Subject: Eagle Rising Final Plat Filing No. 1 (Minor) SF2225

We are responding in EDARP to all Engineering and Planning comments on our Eagle Rising Final Plat No. 1, from our September 7, 2023 submittal responses through the last round of County review comments. We are including our "EDARP Review Comment Tracker for the Eagle Rising Final Plat No. 1" to ensure that we have responded to all County review comments. Our responses and updated documents constitute a complete Applicant response.

| Submittal Name: | | EDARP Review Comments | | | | | | | | | | | |
|-------------------|---|---|-------------|--------------------|----------------------|------------------|------|---|--------------------------|-------------------------|--|------|--|
| Project Name: | | Eagle Rising Final Plat Filing No. 1 (Minor) SF2225 | | | | | | | | | | | |

SHEET 2 OF 6

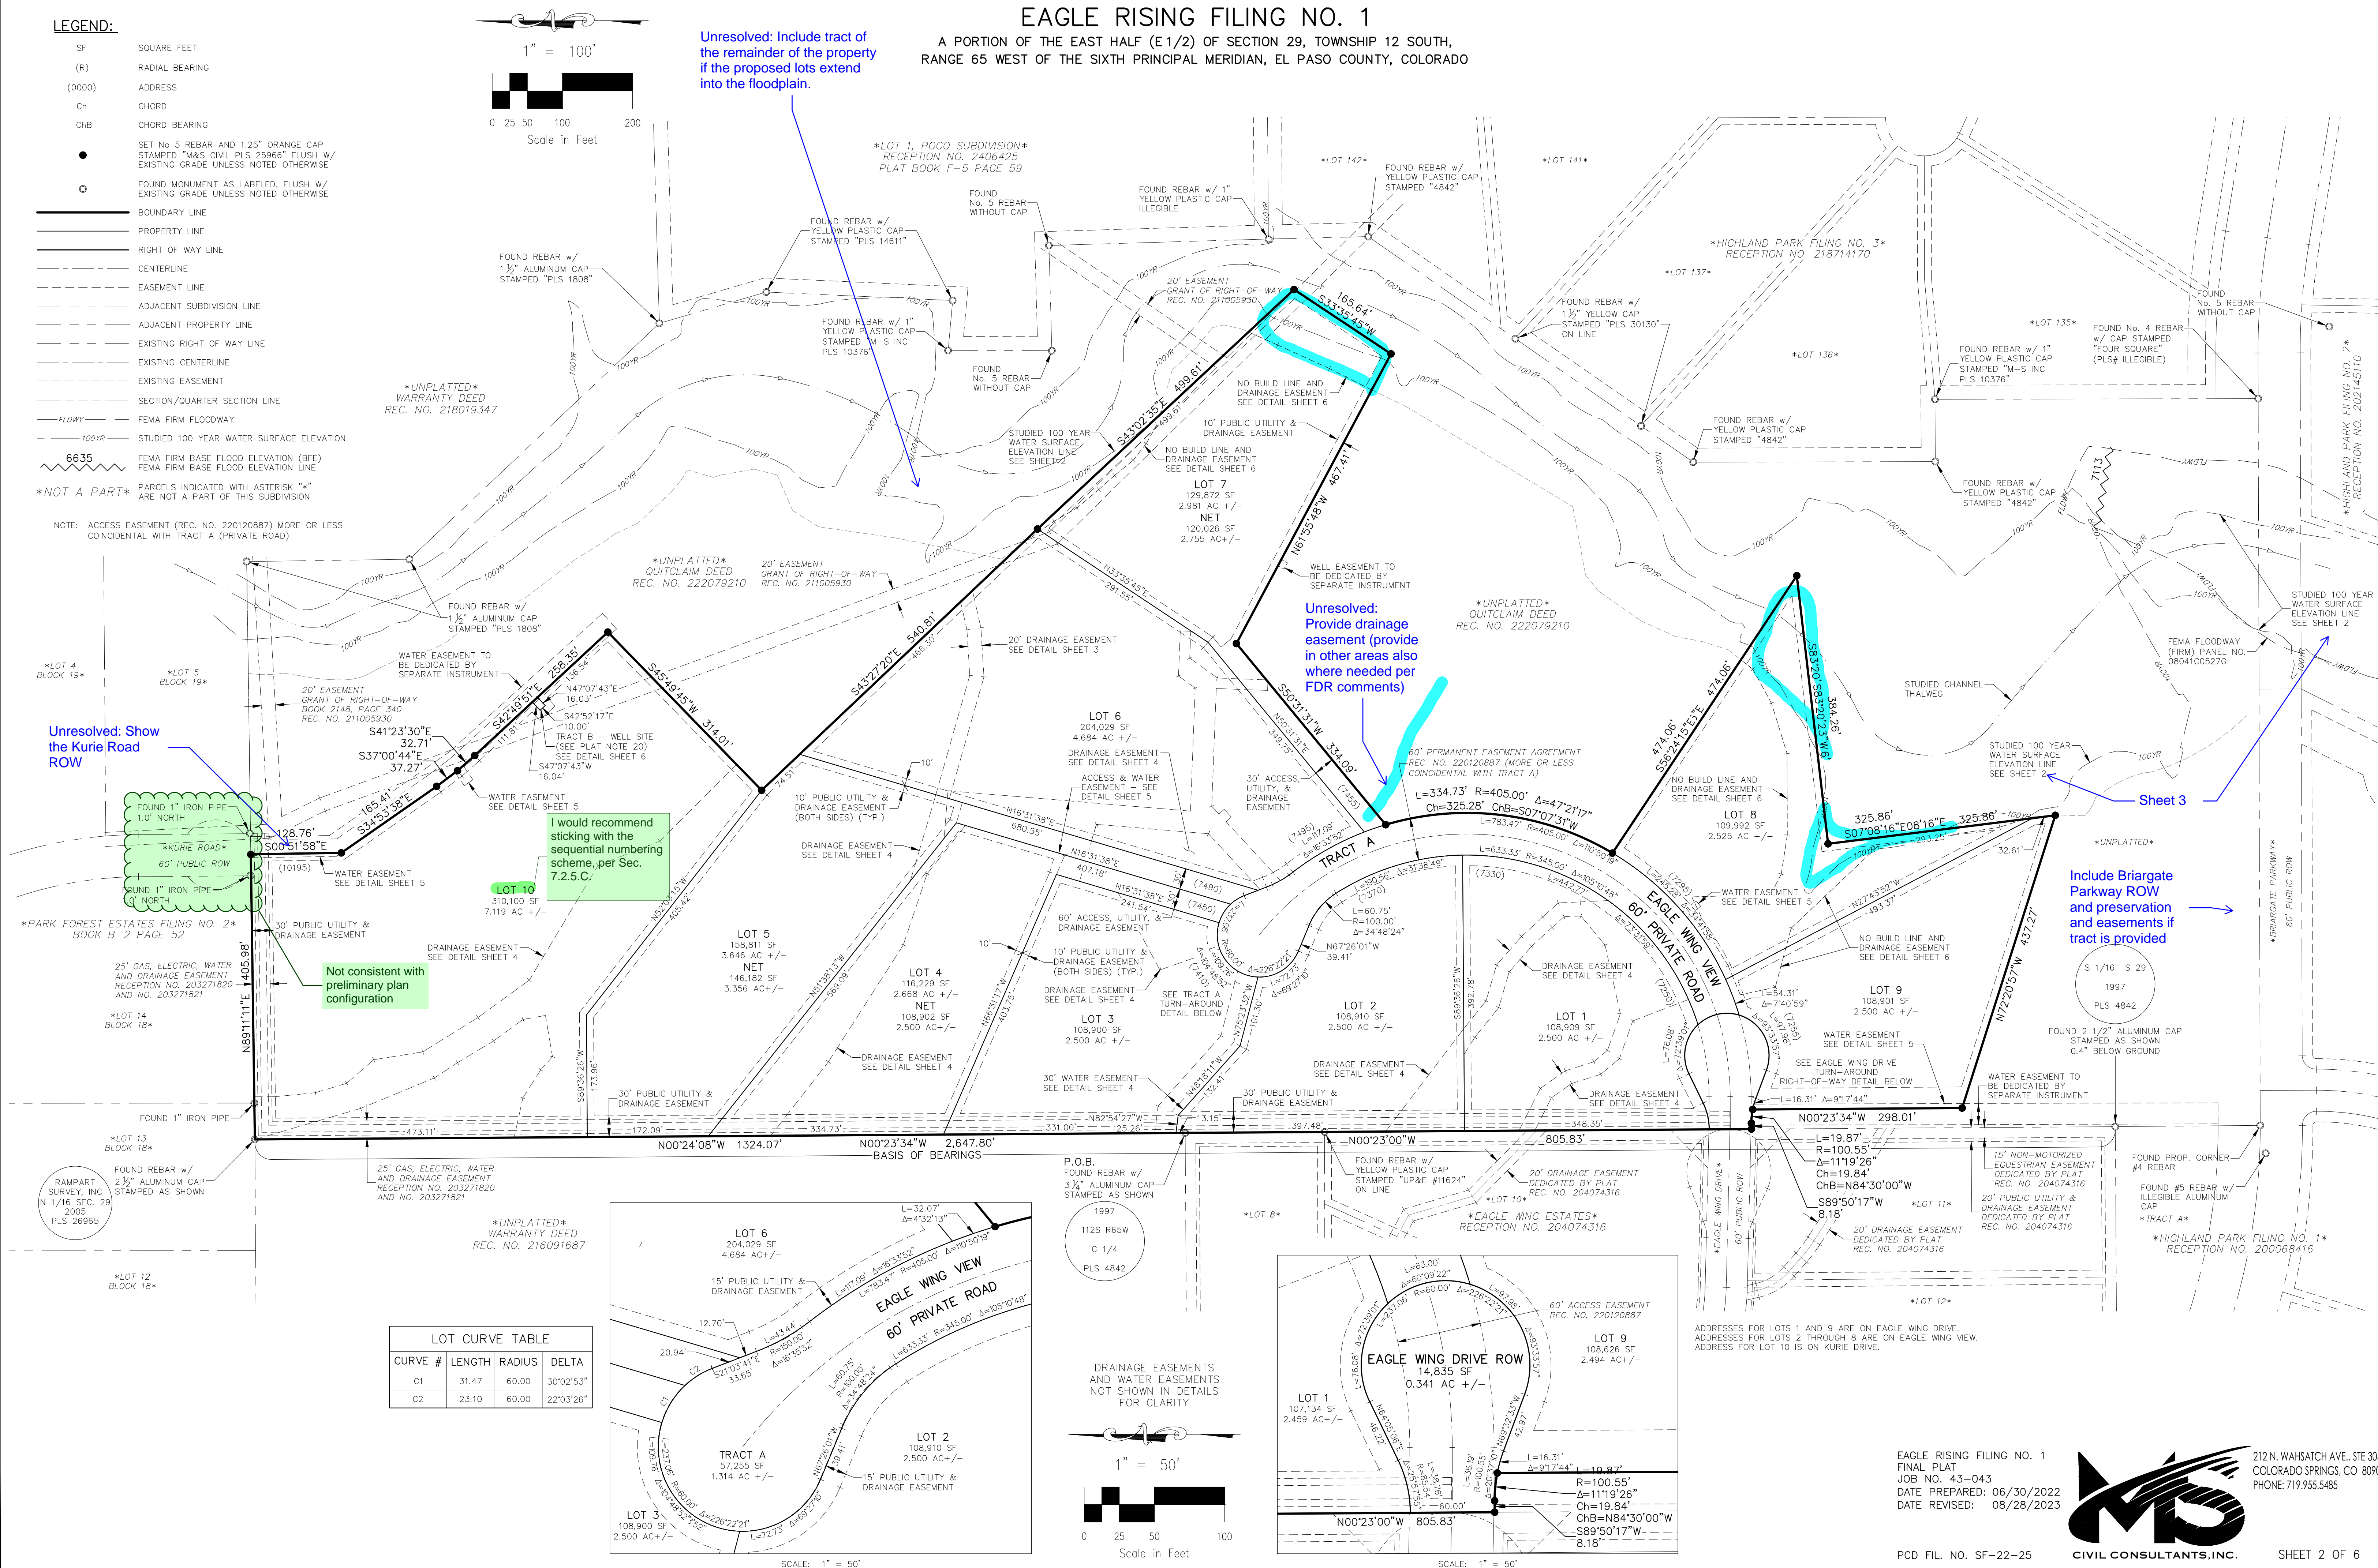
| Comment Number ID | Document Submitted | Agency | Attachments | Reviewer Name | Reviewer Date | Redline Document | Page | Reviewer Comment | Applicants Disposition | Applicant Response Date | Document | Page | Applicant Comment/Response |
|-------------------|---|--------------------------|-------------|---------------|-----------------|------------------|------|---|------------------------|-------------------------|--|------|---|
| 23 | Final Plat Eagle Rising Filing No 1 | PCD Engineering Division | Yes | Ryan Howser | 10/5/2023 13:20 | (Plat redlines) | 2 | Not consistent with preliminary plan configuration | C - Disapproved | 11/20/2023 | 43043 Eagle Rising No 1 Final Plat | n/a | An additional Kurie Road Cul-de-Sac Right of Way is not required on Final Plat Eagle Rising Filing No. 1 Not required per Palmer and Kilgore from Meeting Minutes on 10/25/23 with EPC staff. |

| Comment Number ID | Document Submitted | Agency | Attachments | Reviewer Name | Reviewer Date | Redline Document | Page | Reviewer Comment | Applicants Disposition | Applicant Response Date | Document | Page | Applicant Comment/Response |
|-------------------|--|--------------------------|-------------|---------------|-----------------|------------------|------|--|--------------------------|-------------------------|--------------------------------------|------|--|
| 36 | Final Plat Eagle Rising Filing No 1 | PCD Engineering Division | Yes | Jeff Rice | 10/5/2023 13:20 | (Plat redlines) | 2 | Unresolved: Show the Kurie Road ROW | C - Disapproved | 11/20/2023 | 43043 Eagle Rising No 1 Final Plat | n/a | An additional Kurie Road Cul-de-Sac Right of Way is not required on Final Plat Eagle Rising Filing No. 1 Not required per Palmer and Kilgore from Meeting Minutes on 10/25/23 with EPC staff. |
| 37 | Final Plat Eagle Rising Filing No 1 | PCD Engineering Division | Yes | Jeff Rice | 10/5/2023 13:20 | (Plat redlines) | 2 | Unresolved: Include tract of the remainder of the property if the proposed lots extend into the floodplain. | C - Disapproved | 11/20/2023 | 43043 Eagle Rising No 1 Final Plat | n/a | The Eagle Rising Filing No. 1 lots are not part of any Tract. No engineering criteria cited. Adjacent property is not on Final Plat Eagle Rising Filing No. 1. |
| 38 | Final Plat Eagle Rising Filing No 1 | PCD Engineering Division | Yes | Jeff Rice | 10/5/2023 13:20 | (Plat redlines) | 2 | Unresolved: Provide drainage easement (provide in other areas also where needed per FDR comments) | C - Disapproved | 11/20/2023 | 43043 Eagle Rising No 1 Final Plat | n/a | Off site drainage easements not part of Final Plat Eagle Rising Filing No. 1. Drainage easements are provided as shown for Final Plat Eagle Rising Filing No. 1. |
| 39 | Final Plat Eagle Rising Filing No 1 | PCD Engineering Division | Yes | Jeff Rice | 10/5/2023 13:20 | (Plat redlines) | 2 | Include Briargate Parkway ROW and preservation and easements if tract is provided | C - Disapproved | 11/20/2023 | 43043 Eagle Rising No 1 Final Plat | n/a | Red Herring Provide engineering citation or state statute No tract is provided. Not required on Final Plat Eagle Rising Filing No. 1 Adjacent property is not on Final Plat Eagle Rising Filing No. 1. |

NO-BUILD LINE AND DRAINAGE EASEMENT DETAIL
 LOTS 8 & 9
 SCALE: 1" = 50'

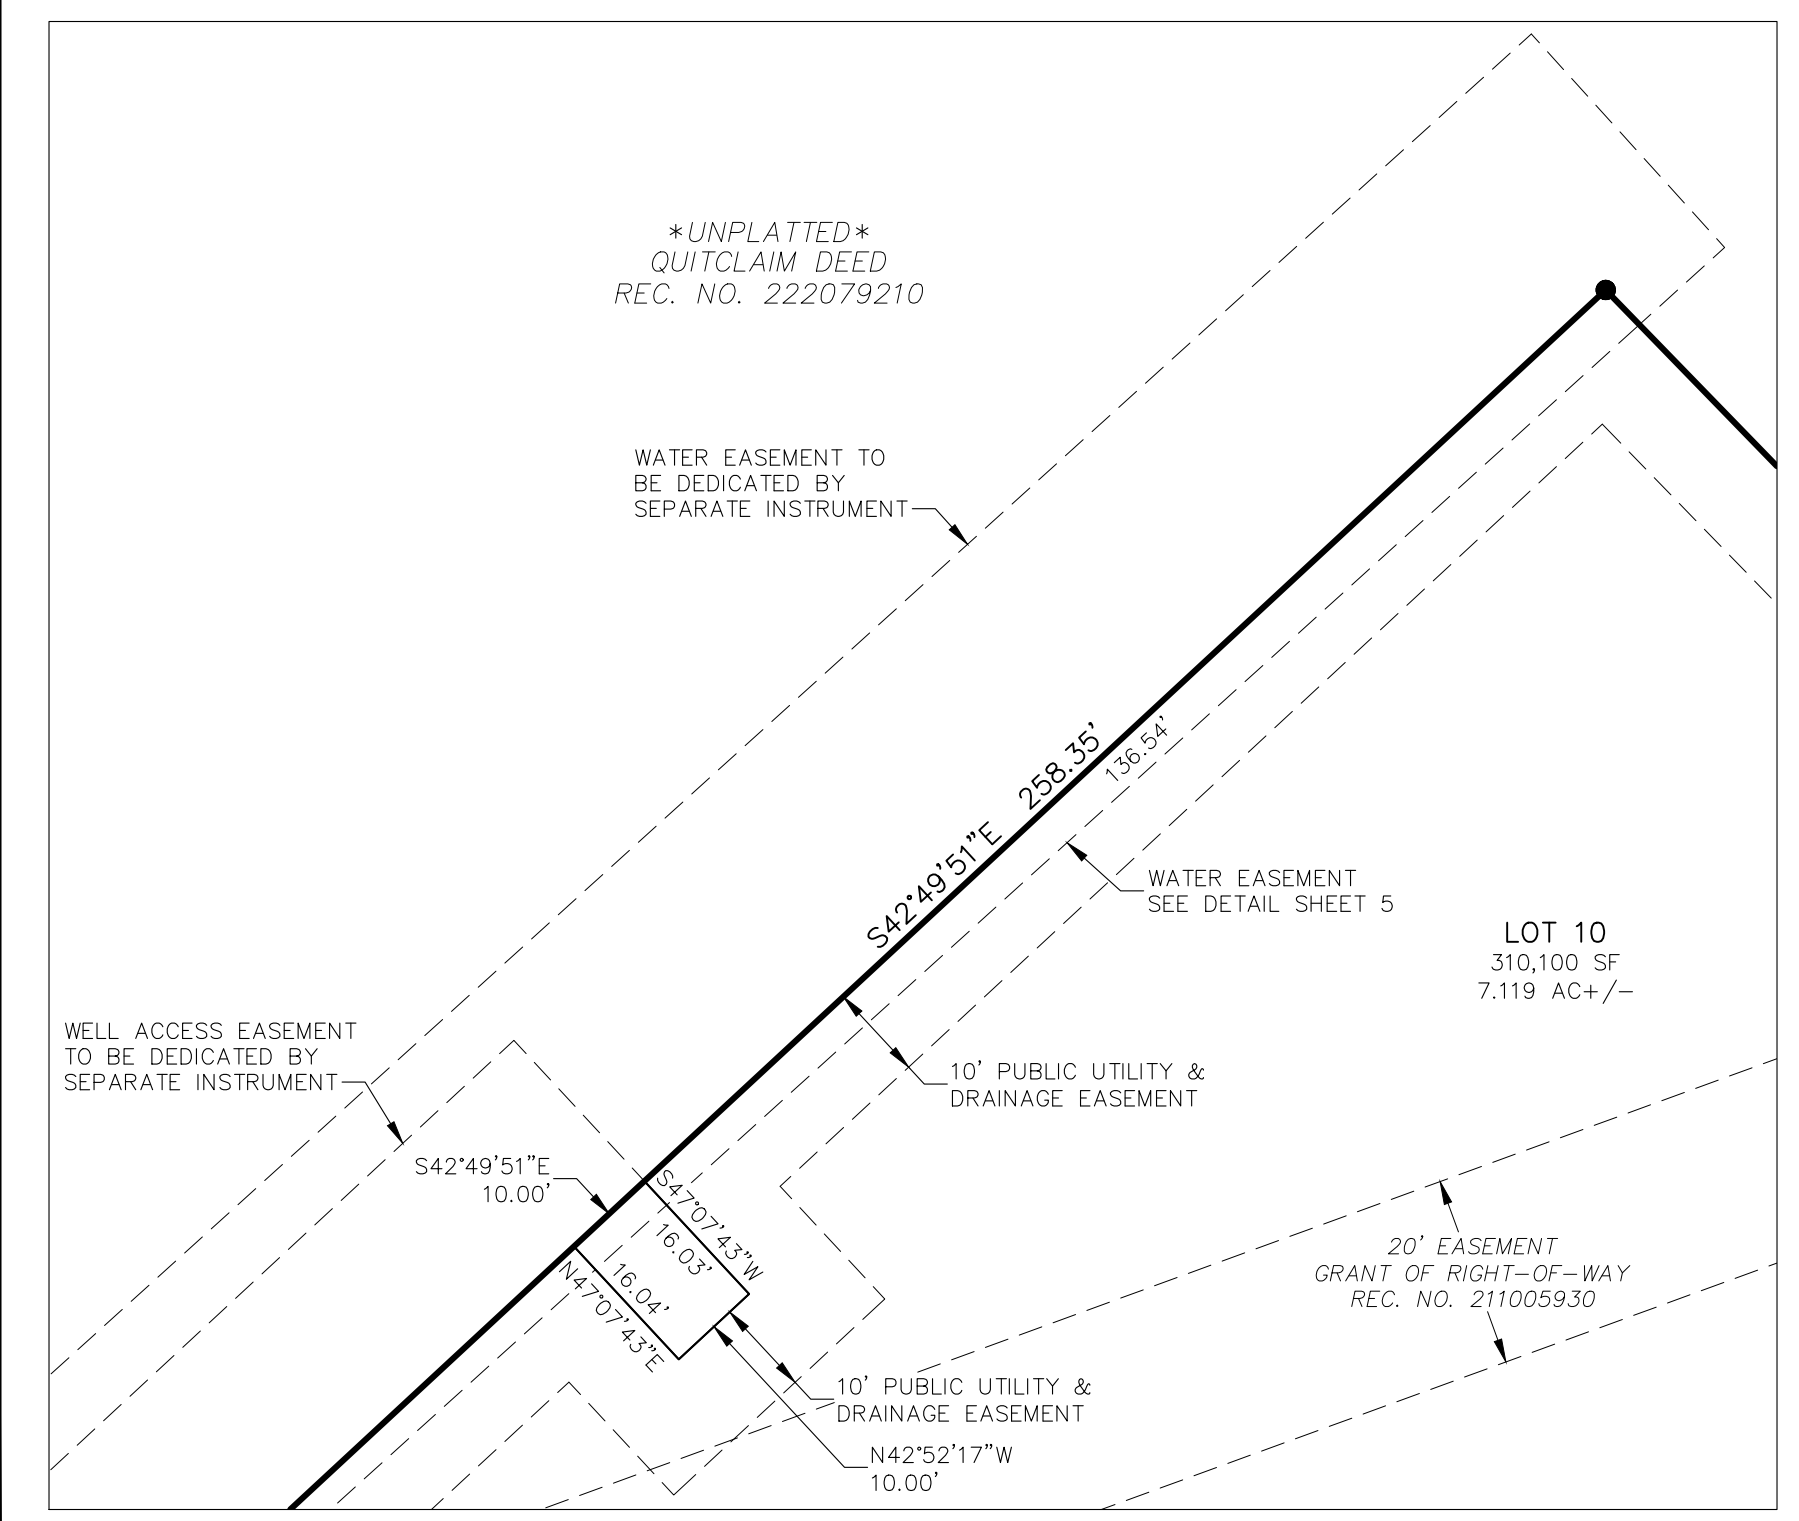
| Comment Number ID | Document Submitted | Agency | Attachments | Reviewer Name | Reviewer Date | Redline Document | Page | Reviewer Comment | Applicants Disposition | Applicant Response Date | Document | Page | Applicant Comment/Response |
|-------------------|--|--------------------------|-------------|---------------|-----------------|------------------|------|--|--------------------------|-------------------------|--------------------------------------|------|--|
| 41 | Final Plat Eagle Rising Filing No 1 | PCD Engineering Division | Yes | Jeff Rice | 10/5/2023 13:20 | (Plat redlines) | 3 | State the source of the elevations | A - Approve | 11/20/2023 | 43043 Eagle Rising No 1 Final Plat | 2 | Studied Water Surface Elevation (SWE) from Final Plat Eagle Rising Filing No. 1 Drainage Report Not in FEMA flood plain |
| 43 | Final Plat Eagle Rising Filing No 1 | PCD Engineering Division | Yes | Jeff Rice | 10/5/2023 13:20 | (Plat redlines) | 3 | the property isn't platted?? Is this a floodplain elevation plan? | A - Approve | 11/20/2023 | 43043 Eagle Rising No 1 Final Plat | 2 | "AS PLATTED" removed. |

DRAWN L.L. CHECKED
DATE 1/25/23
SCALE AS SHOWN
JOB NO. 221458
FIGURE No. 3

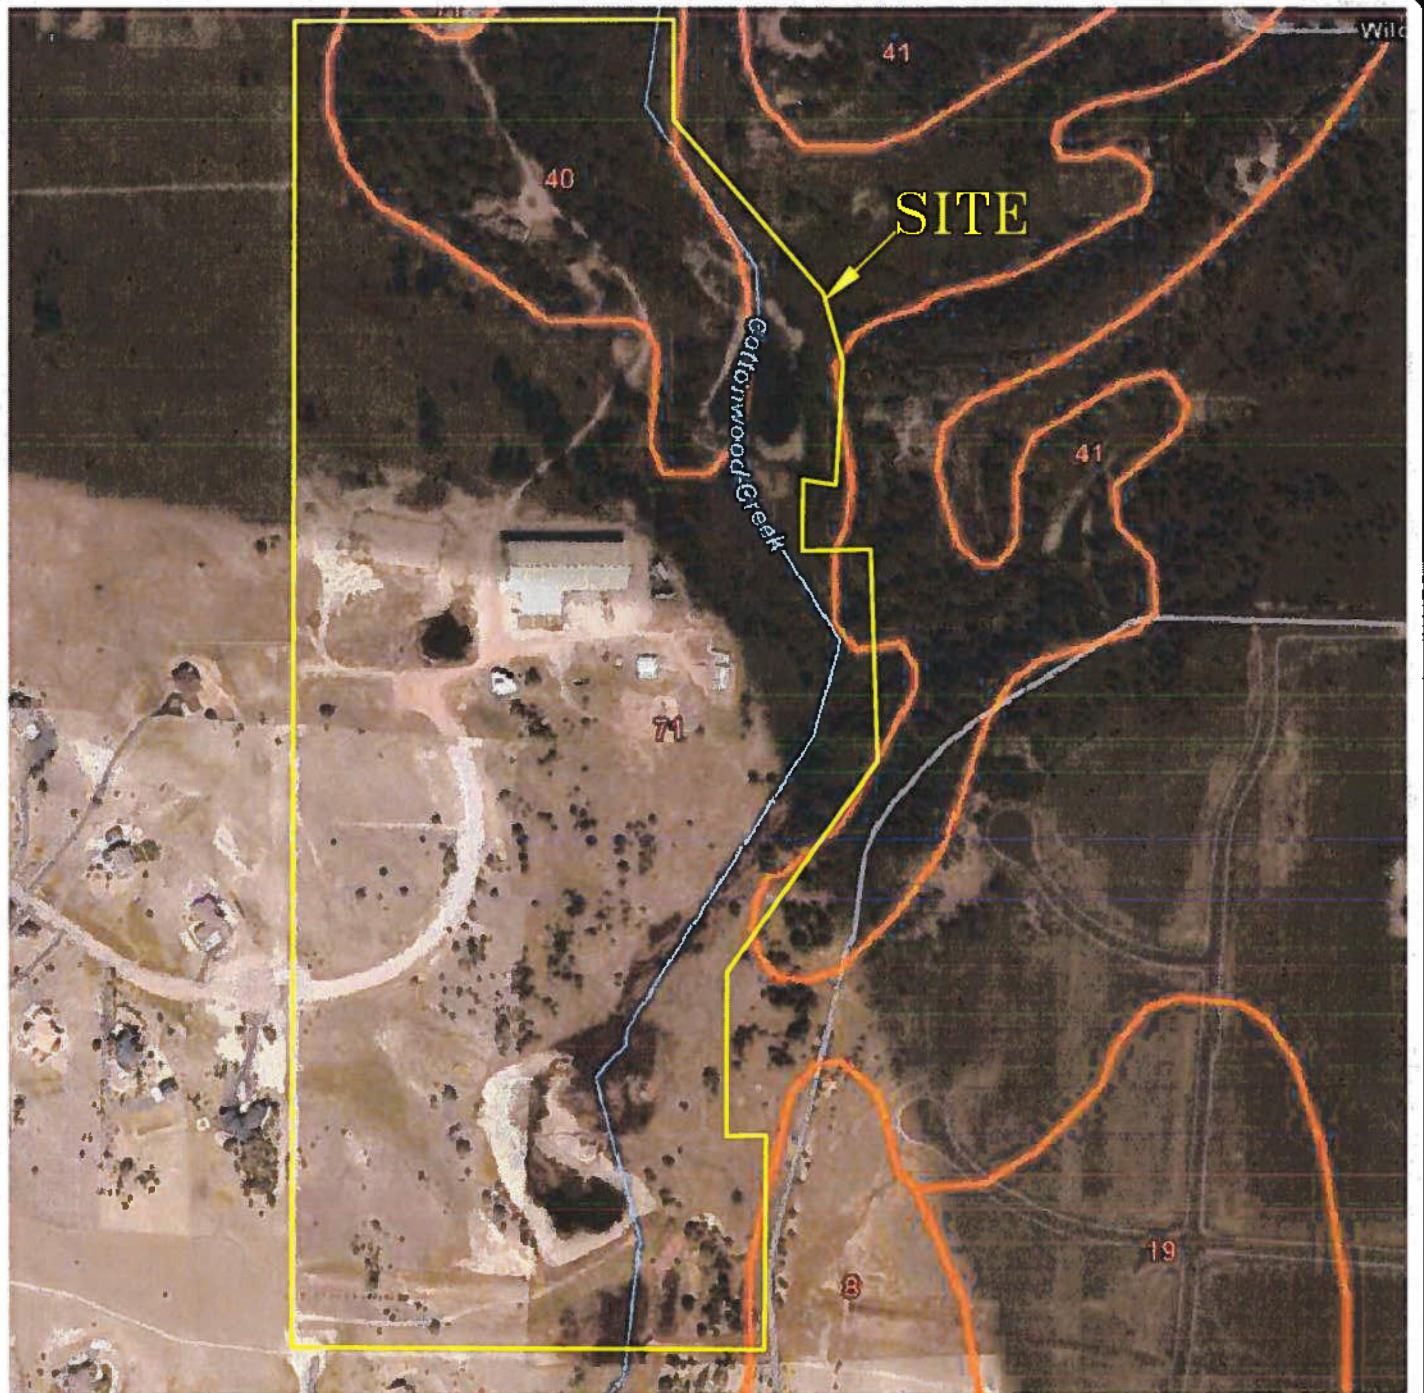
| Submittal Name: | | EDARP Review Comments | | | | | | | | | | | |
|-------------------|---|---|-------------|--------------------|----------------------|------------------|------|---|--------------------------|-------------------------|--|------|--|
| 2 | Final Plat Eagle Rising Filing No 1 | Colorado Geological Survey | No | Amy Crandall, P.E. | 10/4/2023 10:22 | EDARP Comment | - | 1. Entech's revised report (Entech Engineering, Inc., Revised January 25, 2023) includes an older version of the site plan (Figure 3) and should be updated to include the current plat (MS Civil Consultants, Inc., August 28, 2023). | A - Approve | 11/20/2023 | Soil, Geology, Geologic Hazard Study | 25 | Report Figure 3 and Figure 6 now dated 1/25/2023. Plat was not used for the Entech report. |
